FIVE ESTUARIES OFFSHORE WIND FARM DEVELOPMENT CONSENT ORDER

PINS REFERENCE EN010115

**DEADLINE 3: WRITTEN SUBMISSION OF ORAL
REPRESENTATIONS MADE ON BEHALF OF
THE PORT OF LONDON AUTHORITY
AT ISH3 AND ISH4**

Figure 2.1: Overview of area of interest for NIP (including concurrent activity areas).

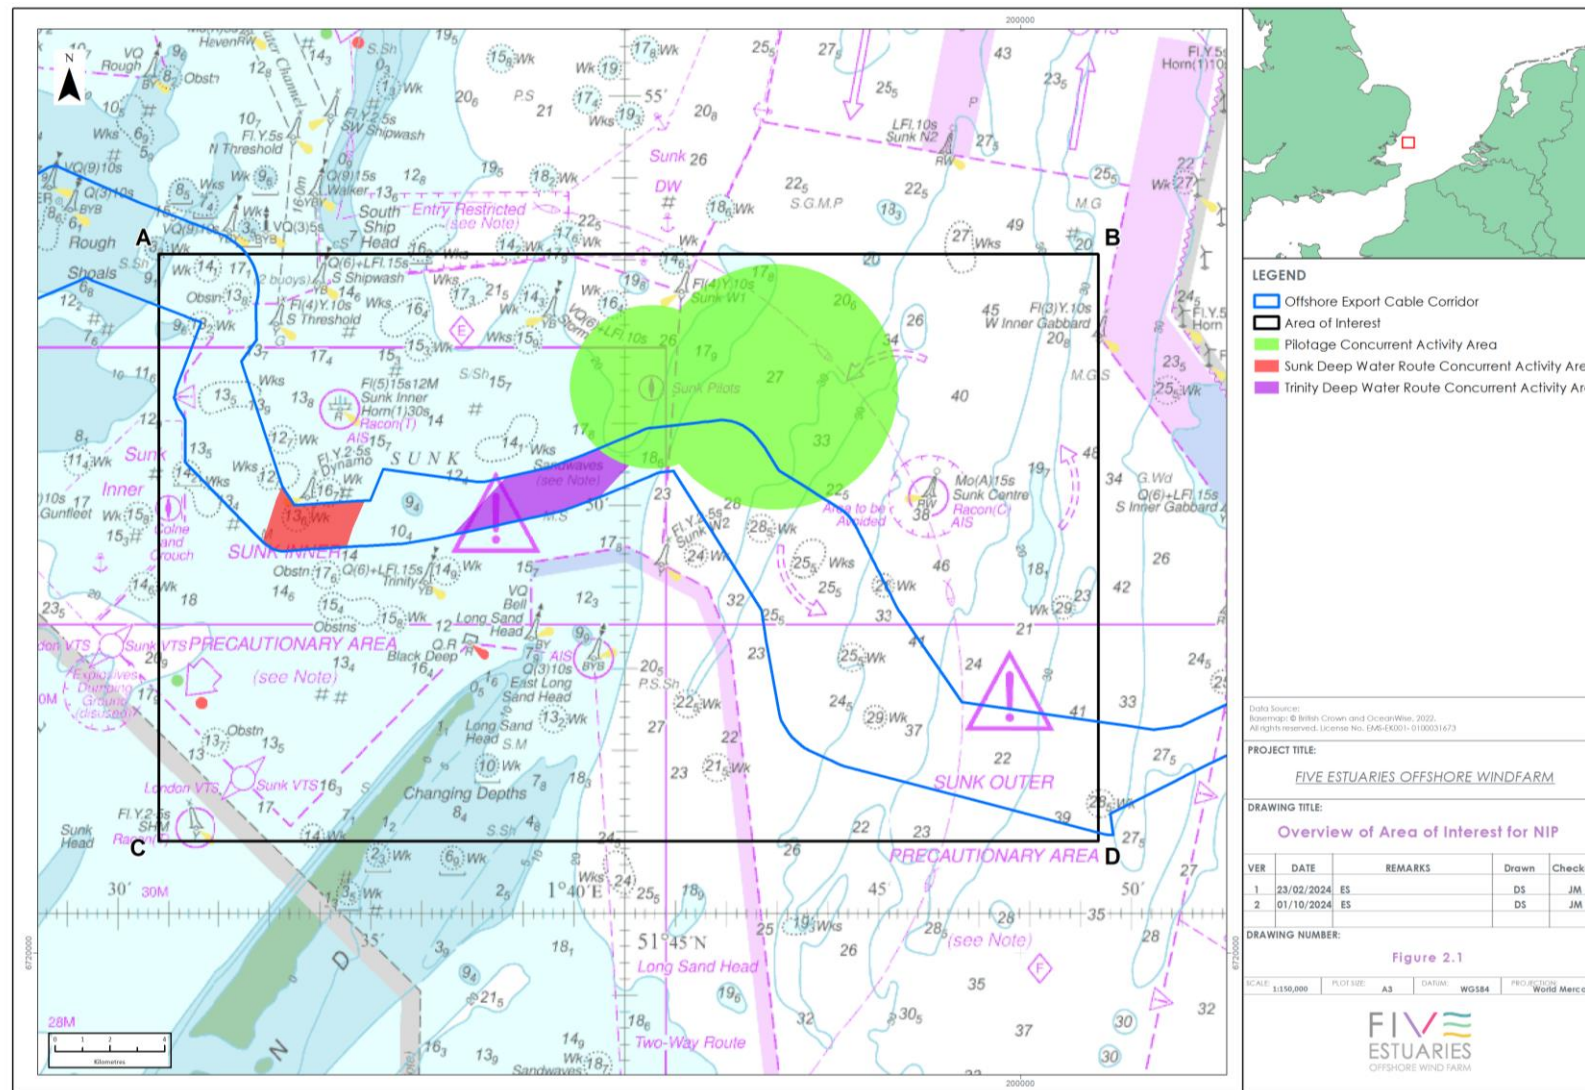
e) Potential impacts for shipping if construction and/or maintenance activities associated with Five Estuaries coincide with other projects	<p>2 RESPONSE TO ITEM 3.3(E)</p> <p>The Applicant has proposed that the issue of impacts on shipping as a result of construction and/or maintenance activities coinciding with other projects is dealt with through the Navigation Installation Plan (NIP) and the restrictions on working concurrently (more specifically, in paragraph 4.2.7 of the outline NIP). The PLA considers that based on the nature of the discussions with the Applicant so far, it can reach agreement on the outline NIP shortly.</p>

Issue Specific Hearing 3	
Agenda Item 3.3: Effects for Navigation and Shipping	Oral Submission made on behalf of the Port of London Authority
f) Control and mitigation measures set out in the Outline Navigation Installation Plan (NIP), Outline Cable Burial Risk Assessment (CBRA) and Outline Cable Specification and Installation Plan (CSIP)	<p>3 RESPONSE TO ITEM 3.3(F)</p> <p>The PLA is content that it is working through its concerns raised within its Written Representations. There has been progress on the detail in the outline NIP. The PLA requested that the other documents are also reviewed and the Applicant engages on those. The detail regarding cable burial depth was taken out of the outline NIP. The PLA understands that it is going to be put in the CSIP. As such, the PLA is keen to start discussions as to the content of the CSIP. The PLA restated that its primary concern is with the approval process, as previously set out.</p>
